Ref: 17165-Waitara-BCAReportR3-201217R1

WAITARA PUBLIC SCHOOL

**BUILDING CODE OF AUSTRALIA 2016
FINAL DA STAGE REVIEW**

DECEMBER 2017

A SECTION
DA-AR-2000 SCALE 1:100

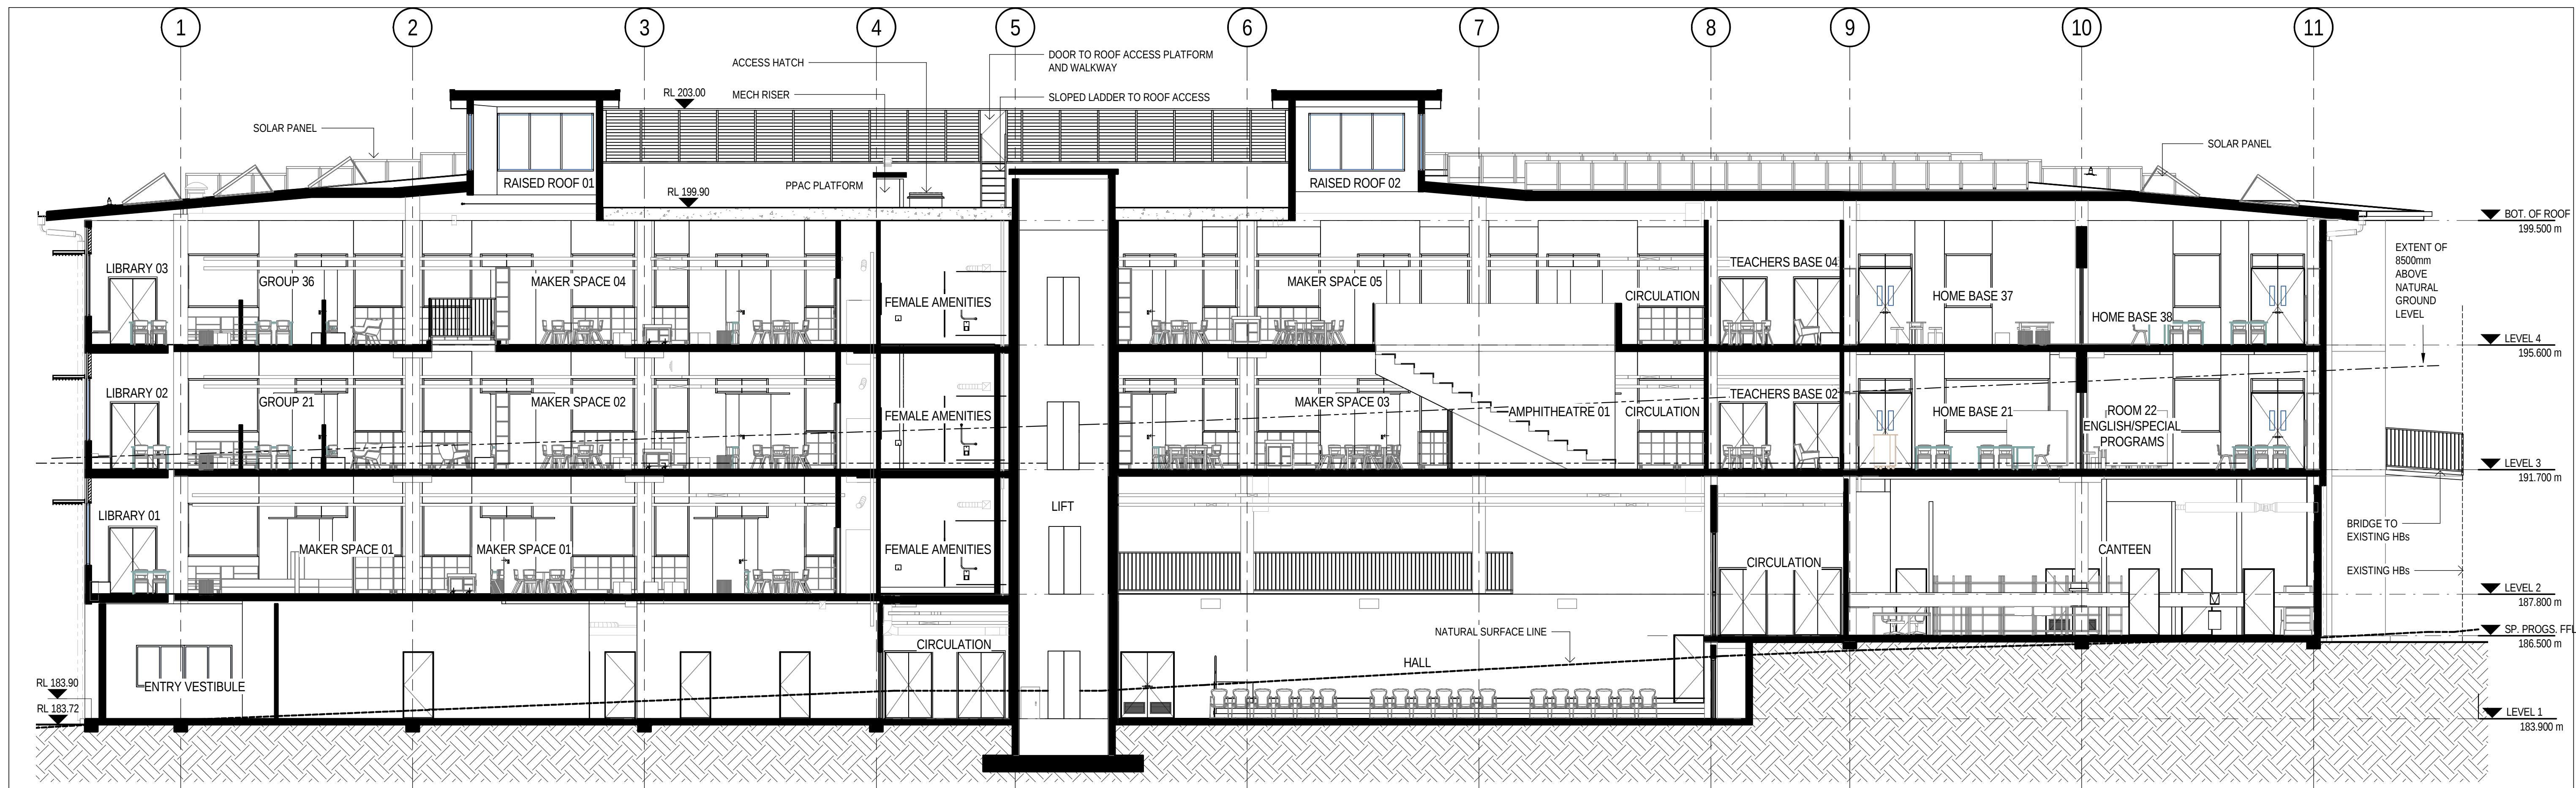
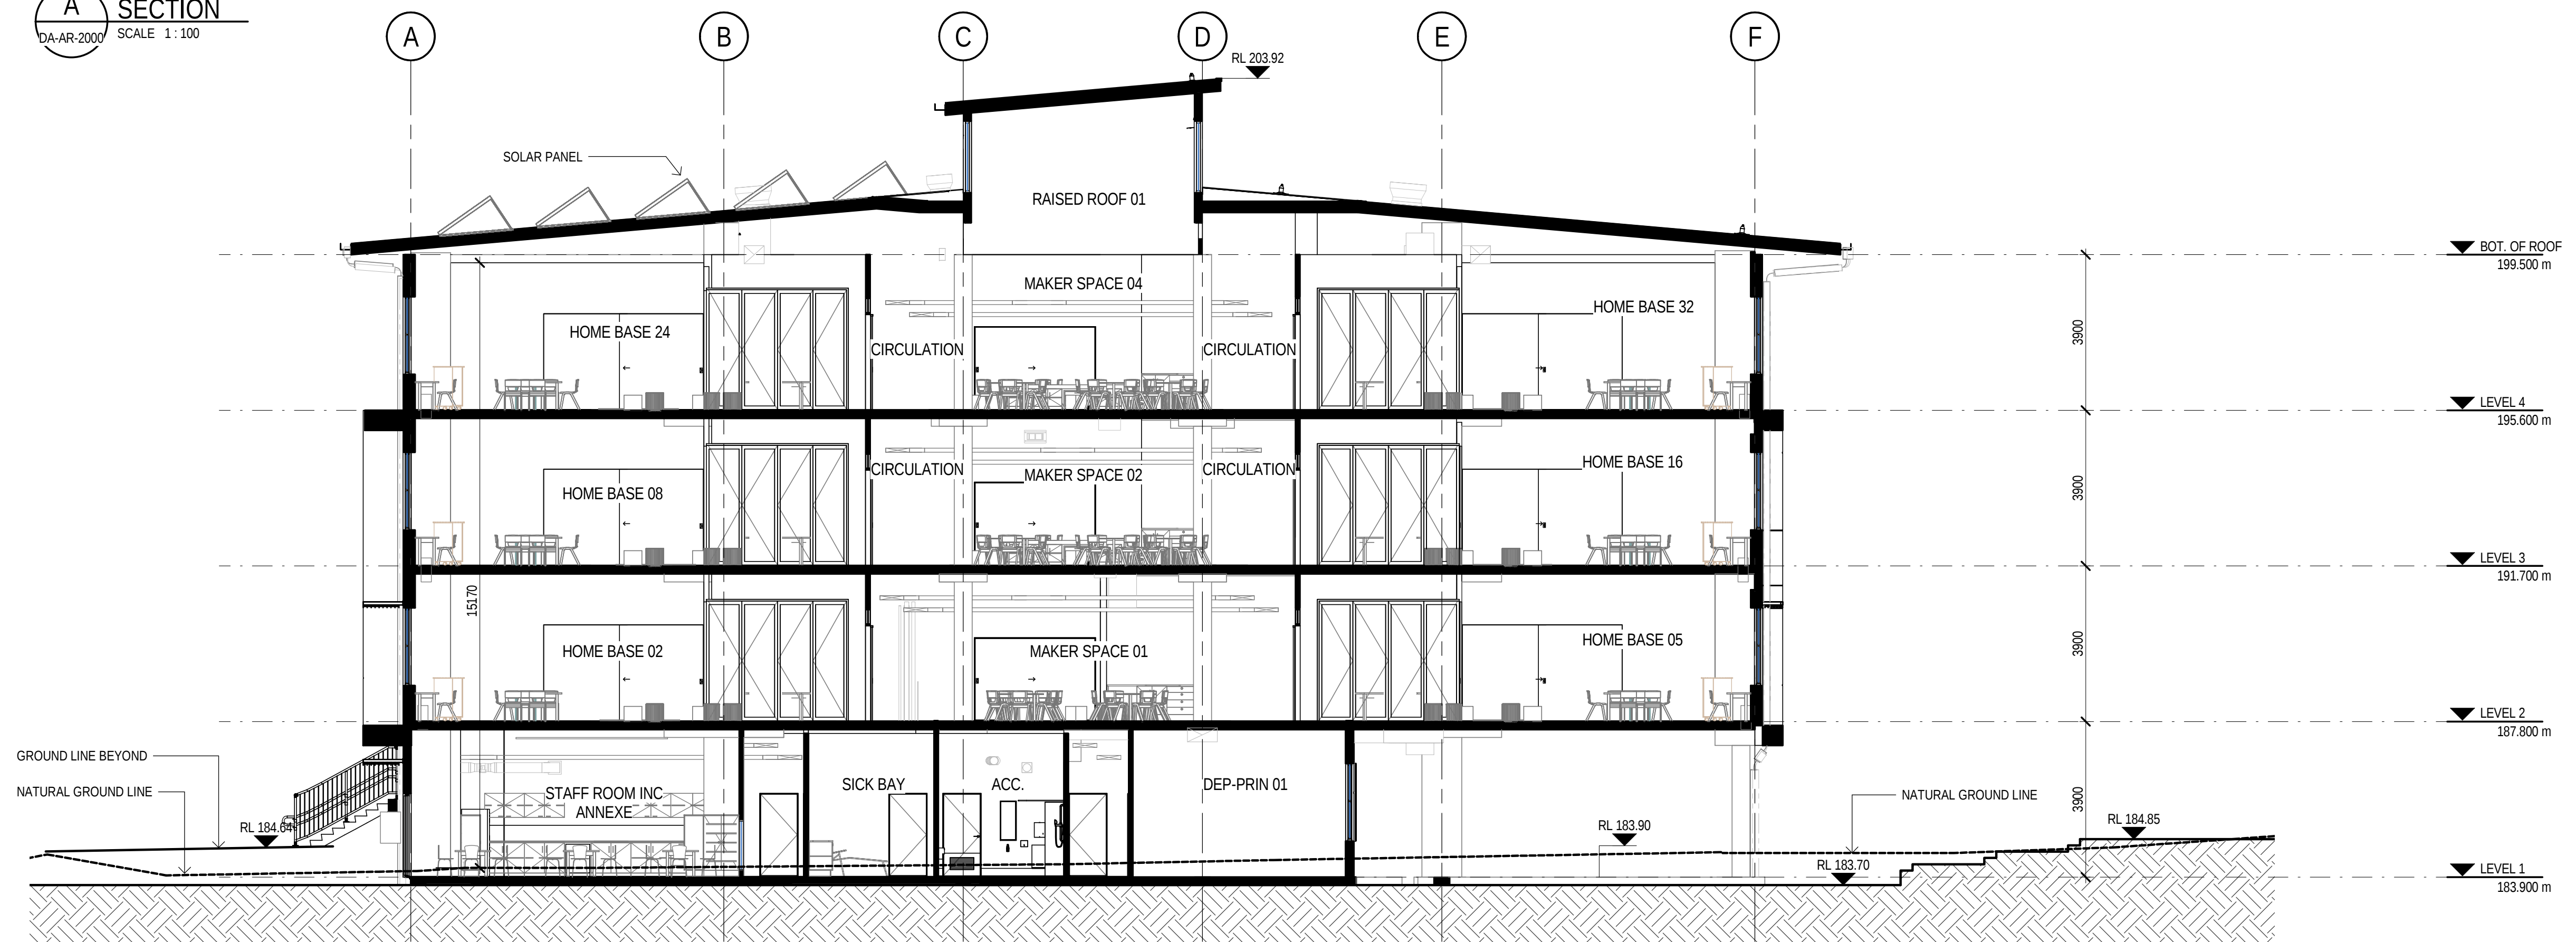
The travel distance from the corner of the homebase 30 on level 4 will have to be reassessed after the furniture plans are provided for review to ensure that the point of choice is within 20m of the starting point. It is expected that egress will be provided from level 3 through the foyer and into the adjoining building.

Please ensure that the hall viewing area on level 2 is not provided with furniture as it may extend the travel distance to the exit to more than the maximum permitted distance of 20m.

The exits serving level 1, 2 and 3 are not distributed as uniformly as practicable within the storey as they are only located on the northern side of the floor plate. At least one fire stair should be relocated to the southern side of the floor or the current arrangement should be justified in a fire engineered alternative solution report.
